RE: Submission – Barangaroo Ferry Hub / Barangaroo Ferry Terminal (SSI- 6727)

This submission is prepared on behalf of Brookfield Commercial Operations (Brookfield), as the managing agent on behalf of Brookfield, the owners of King Street Retail, 1 Shelley Street, 10 Shelley Street, and 12 Shelley Street, Sydney. Brookfield also represents its 30% ownership interest in Cockle Bay Wharf.

Appendix D Indicative Wayfinding Signage Plan and Design and Indicative Opal Card Ticketing Facilities and Location

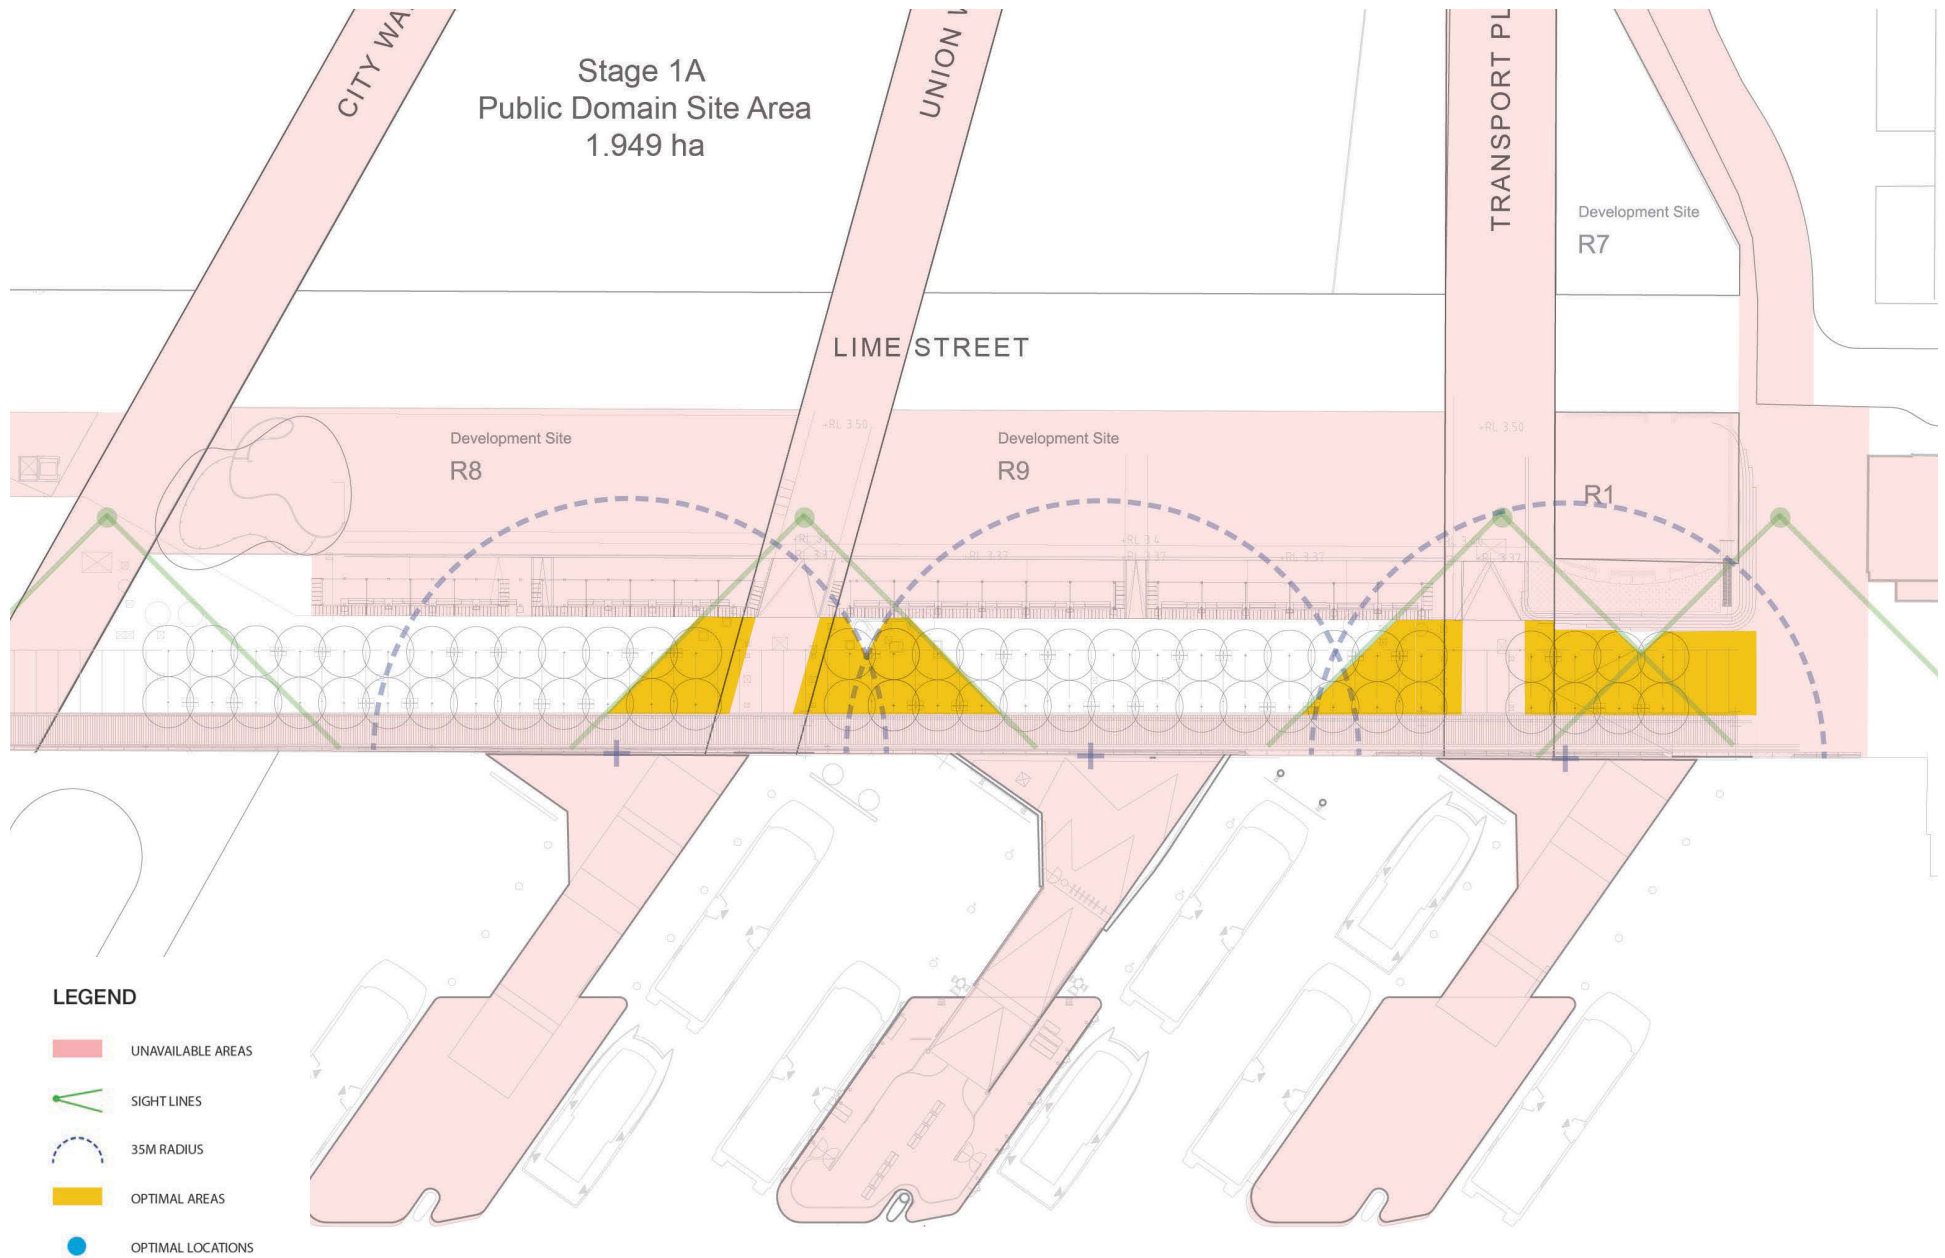
Despite this assertion within the EIS, the proposal has not adequately considered this within the way-finding plan or another strategy. Further, as shown in Figure 4, the way-finding plan has been drafted with consideration of arriving at the site through Barangaroo only, rather than from properties to the south.

Brookfield seek to confirm from the proponent and the Department of Planning and Environment that the proposal will not result in the ‘funnelling’ of pedestrians through Barangaroo at the expense of visitors to King Street Wharf and Darling Harbour.

In response to the above items we request that a way-finding strategy is provided by the proponent as part of this application which clearly considers and accommodates additional signage and way-finding imagery not only to development at Barangaroo, but also to existing and future development to the south.
